## Planning Inspectorate

**Application by RWE Renewables UK Solar and Storage Limited for an Order Granting Development Consent for the Peartree Hill Solar Farm project (Ref EN010157)**

**Action points arising from Issue Specific Hearing 2 (ISH2) on 23 October 2025**

#### Figure 14.1: Study Area for Transport and Access

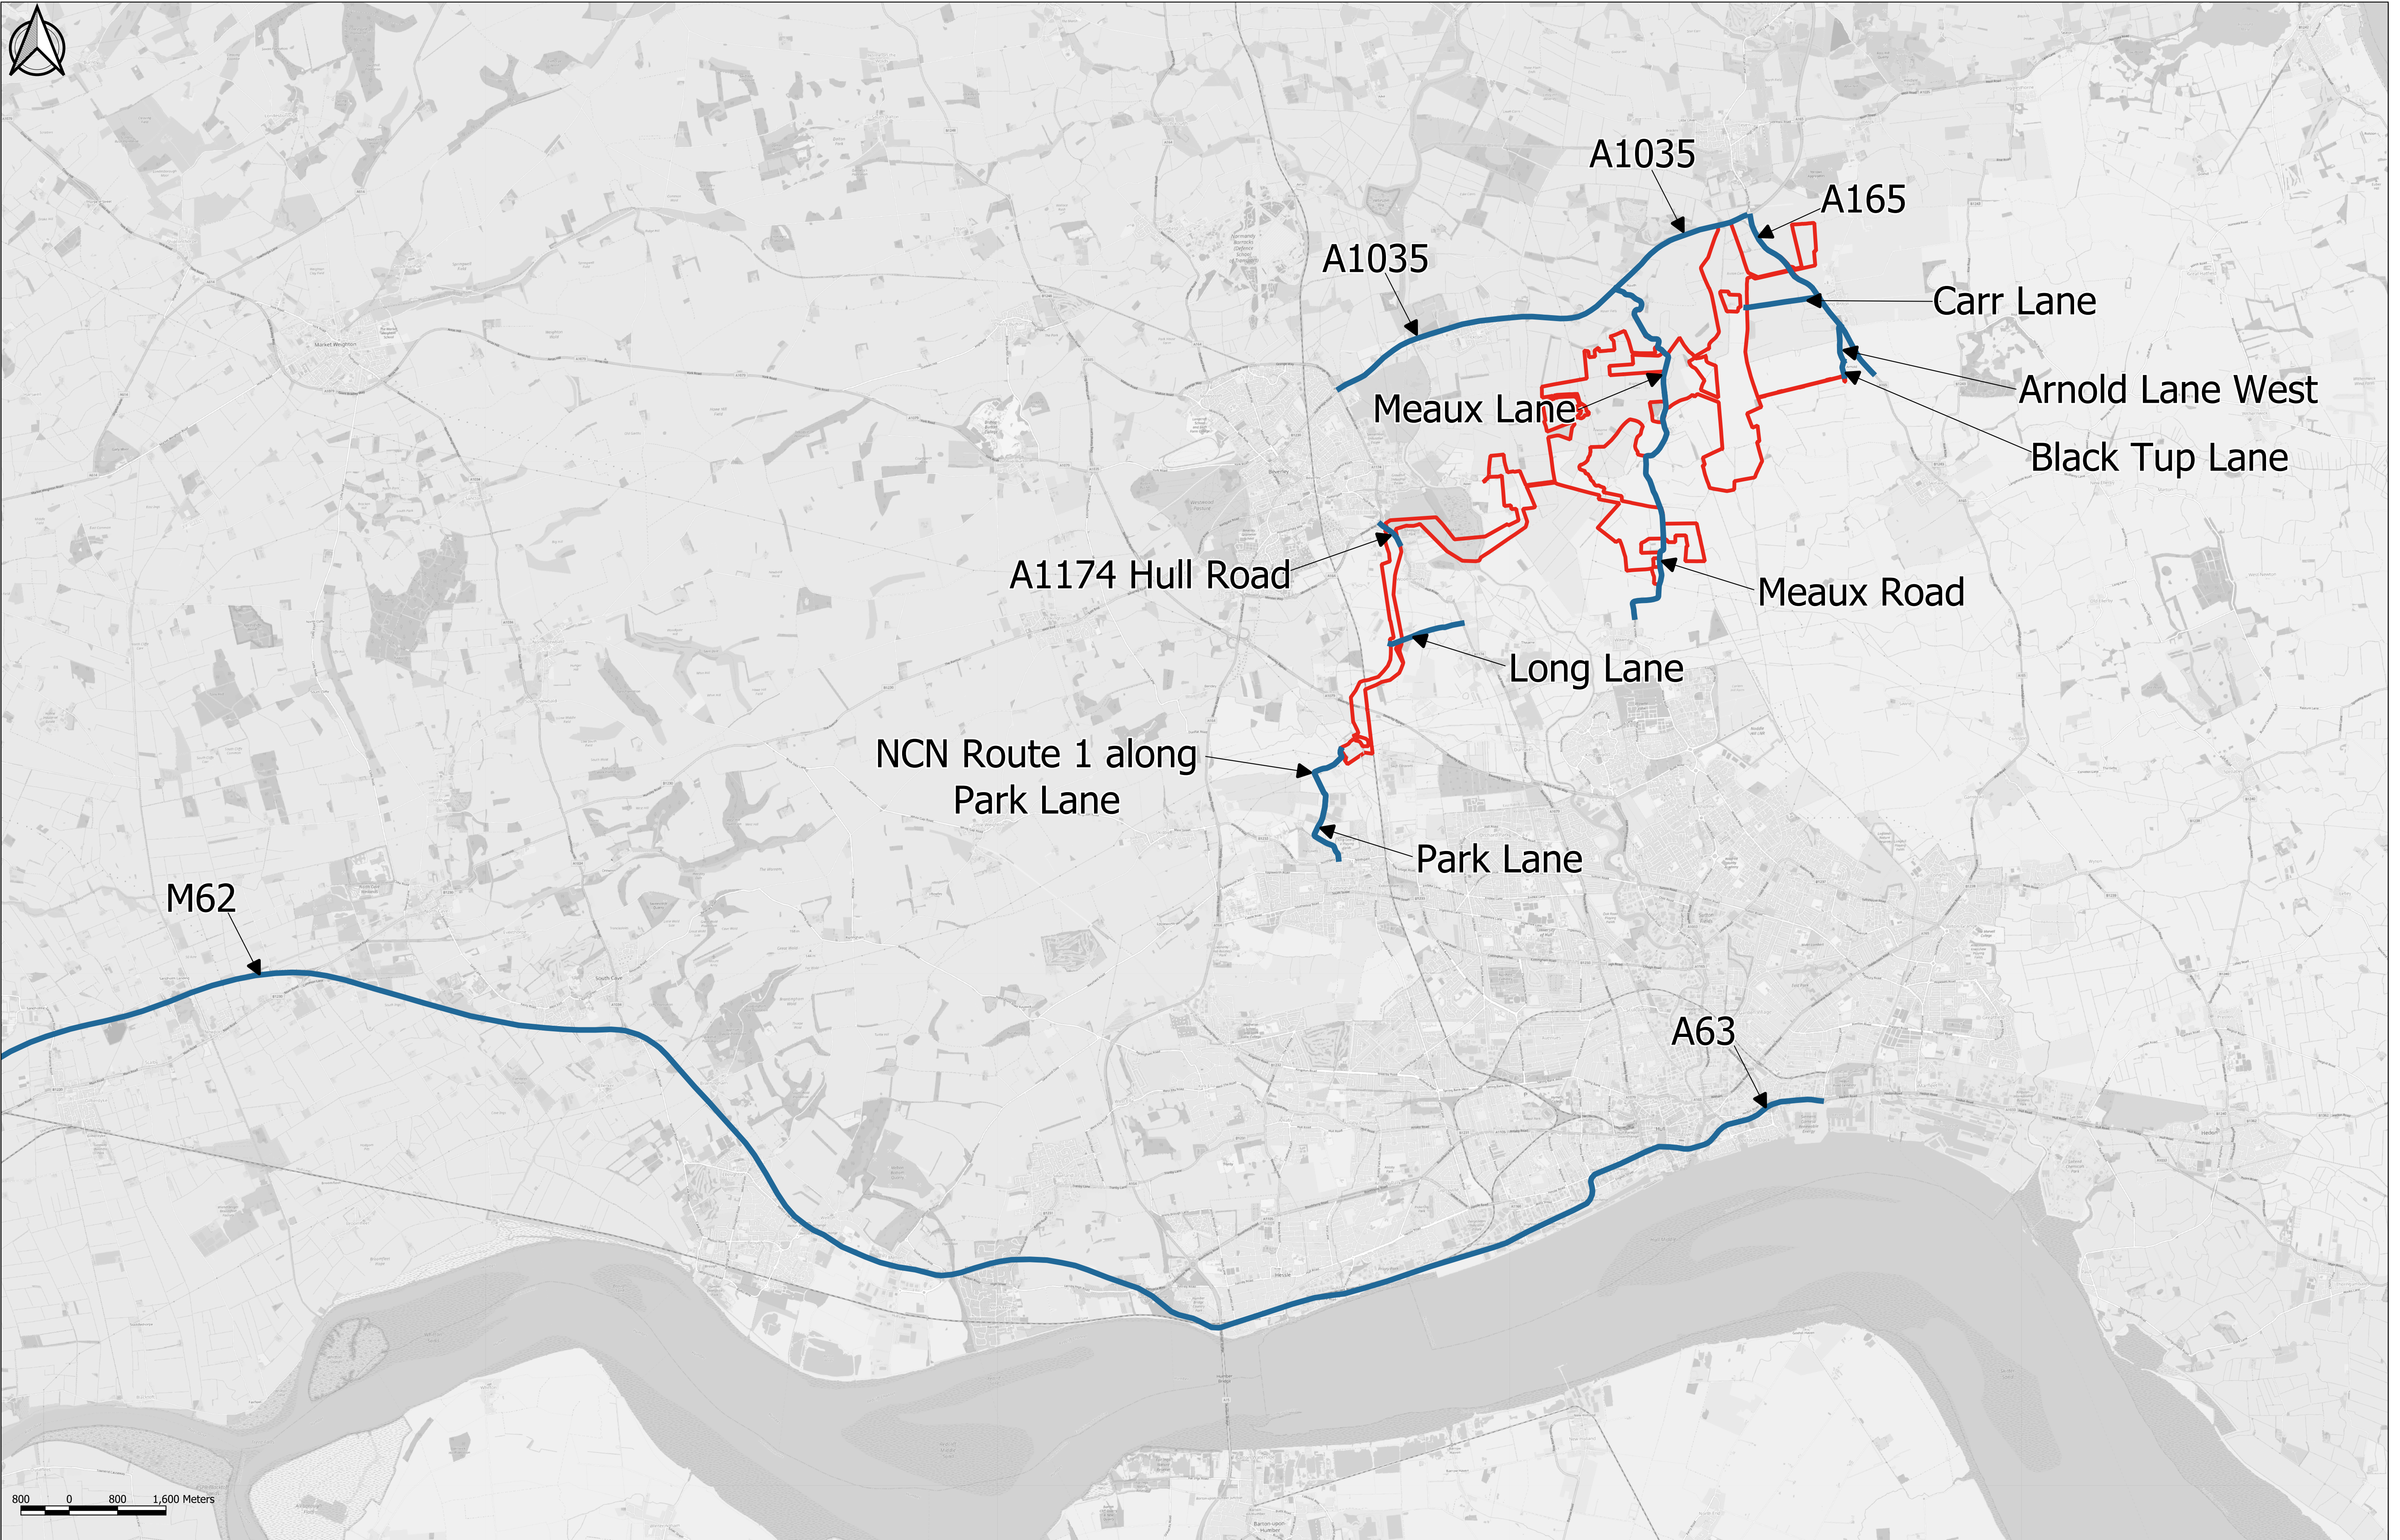
Action No.	Directed to	Action
1.	Applicant	Update Table 14-5 of ES Chapter 14: Transport and Access [REP2-081] to refer to the correct number of heavy goods vehicle (HGV) movements associated with Park Lane (grid connection cable route works).

3.	Applicant	Regarding deliveries of replacement solar panels or other infrastructure by HGV to Field E15 to E17 during the operation of the proposed development, address any need to travel through Weel village and Carr Lane (Weel), and provide details of any subsequent effects in a written submission and/ or an update to ES Chapter 14 [REP2-081].
